## **Colorado Springs, CO**

## **Final Report - Corrections Required** **Application No. LUPL-25-0008**

**Document Filename : 241010\_BLR Village C Land Use Plan.pdf**

# BANNING LEWIS RANCH - VILLAGE C

**BANNING LEWIS RANCH - VILLAGE C**  
 LAND USE PLAN  
 COLORADO SPRINGS, CO  
 LAND USE PLAN

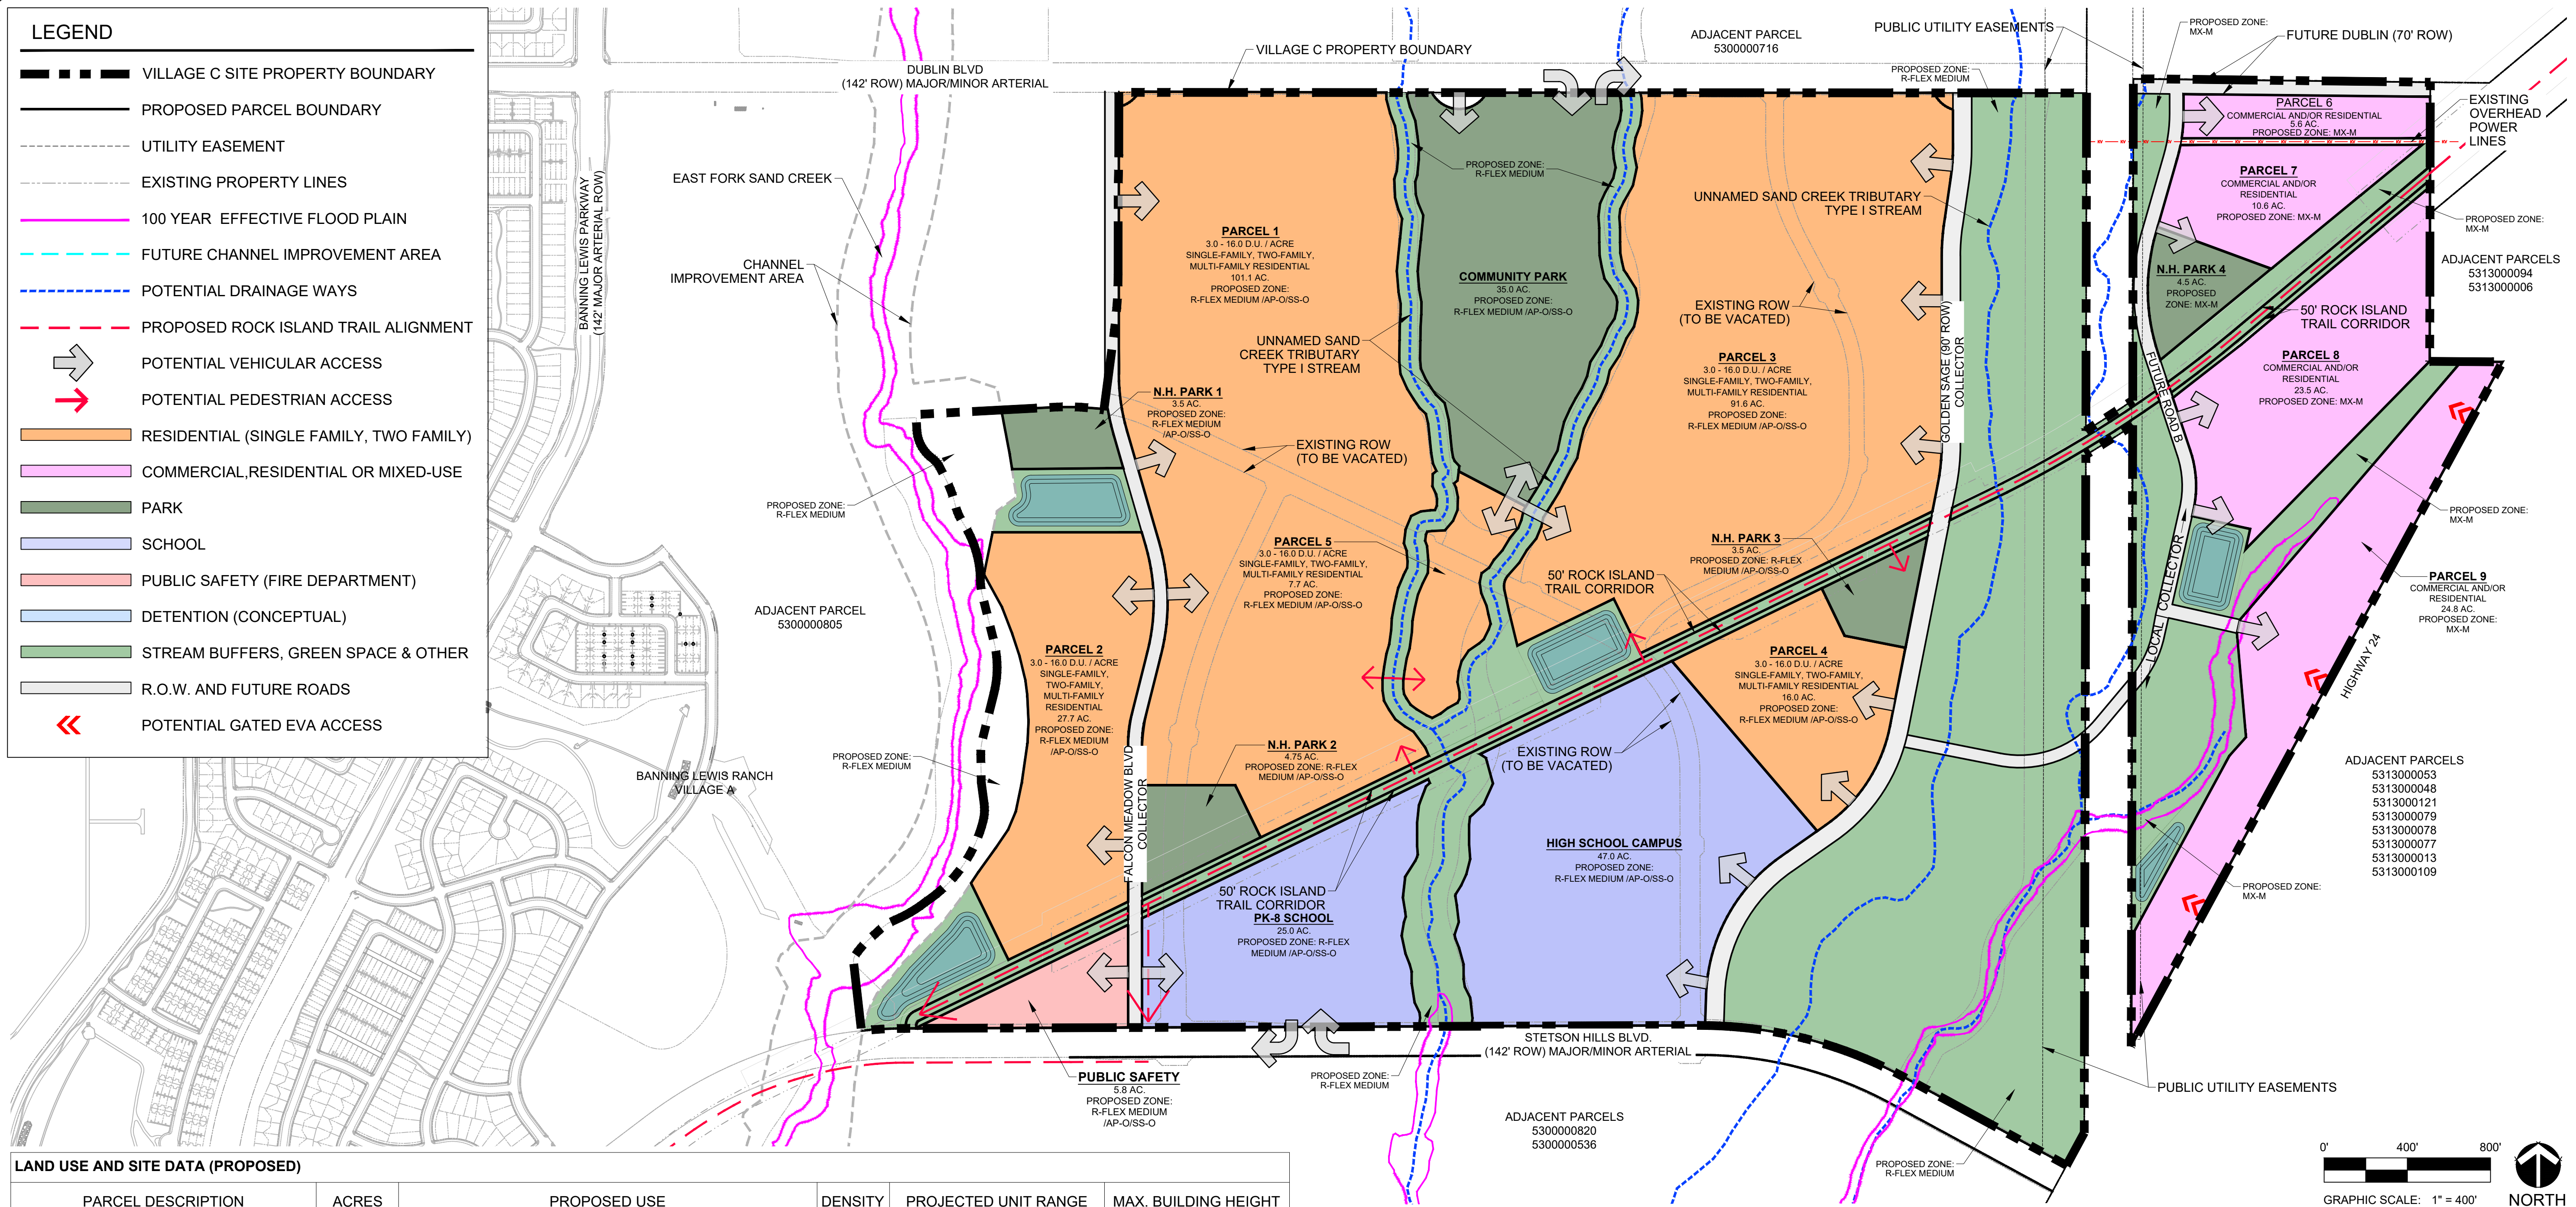
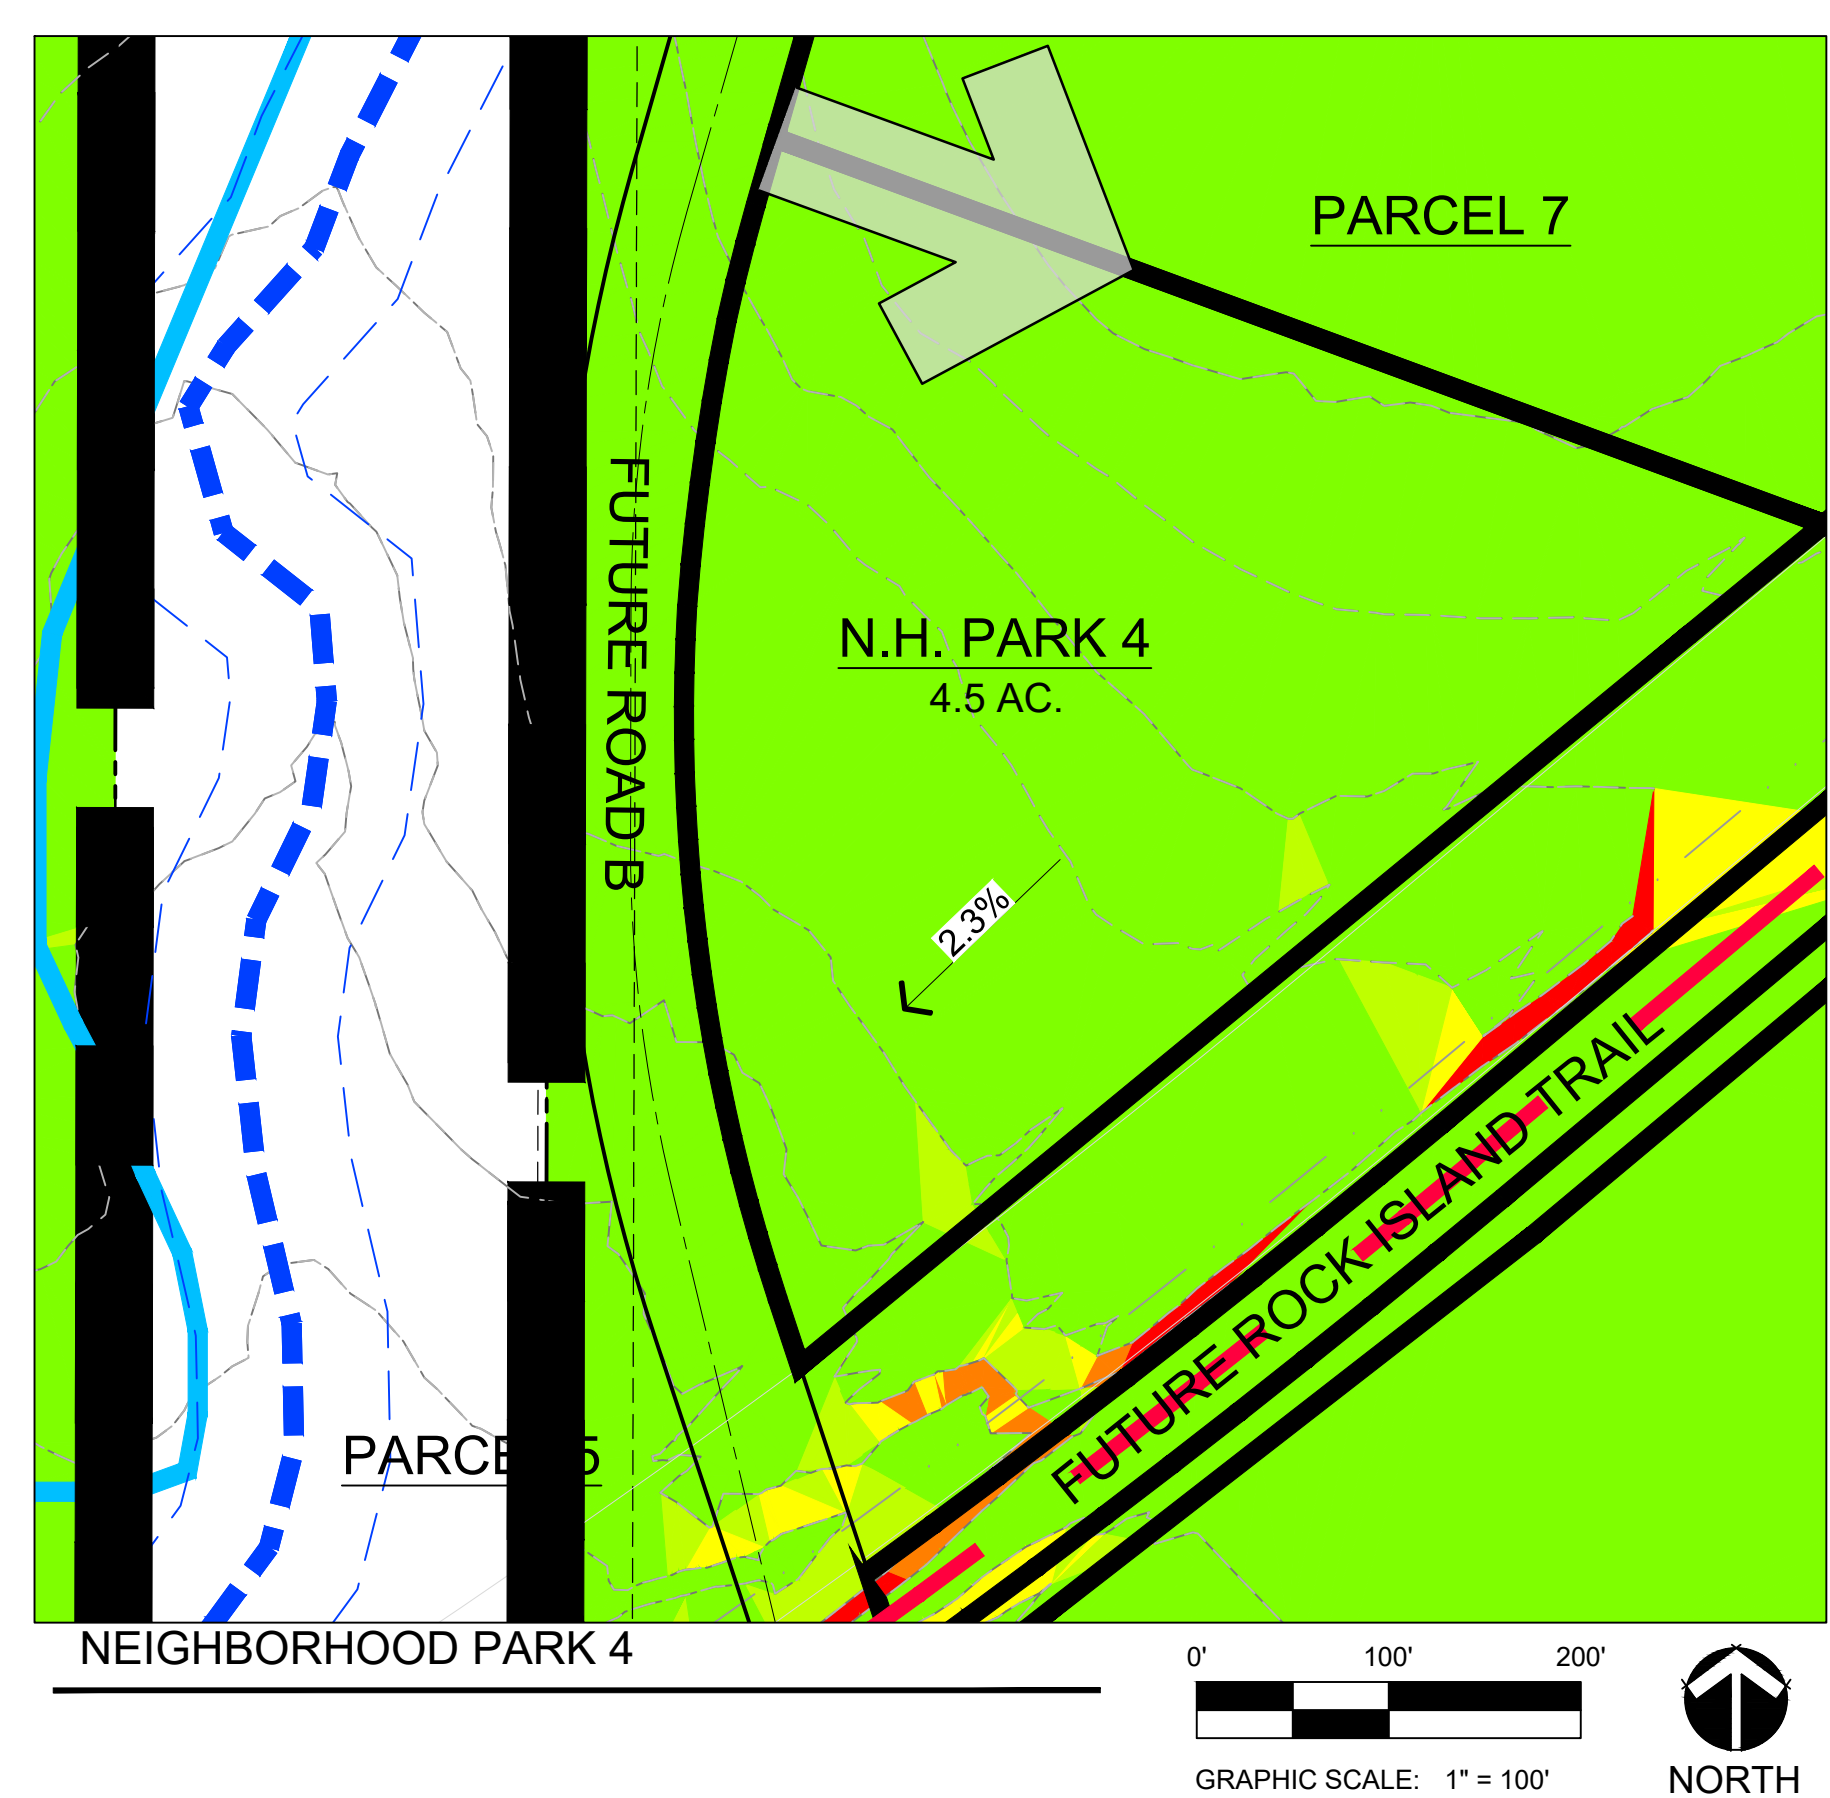
<b>Comment ID</b>	<b>Page Reference</b>	<b>Reviewer : Department</b>	<b>Review Comments</b>
2	2	Zaker Alazzeh : City Eng - Traffic Engineering	The developer shall dedicate the appropriate right-of-way along the northern property line of Parcel 6, located on Dublin Boulevard. This dedication must align with the western property line right-of-way existing roadway and meet the city's standards. Please coordinate with city traffic engineering on the ROW dedication.
1	1	Matthew Alcuran : Col Springs Utilities	**Springs Utilities comment to applicant: Springs Utilities comments will be provided at the time of the required Preliminary Utility and Public Facilities Plan submittal associated with the development plan entitlement.
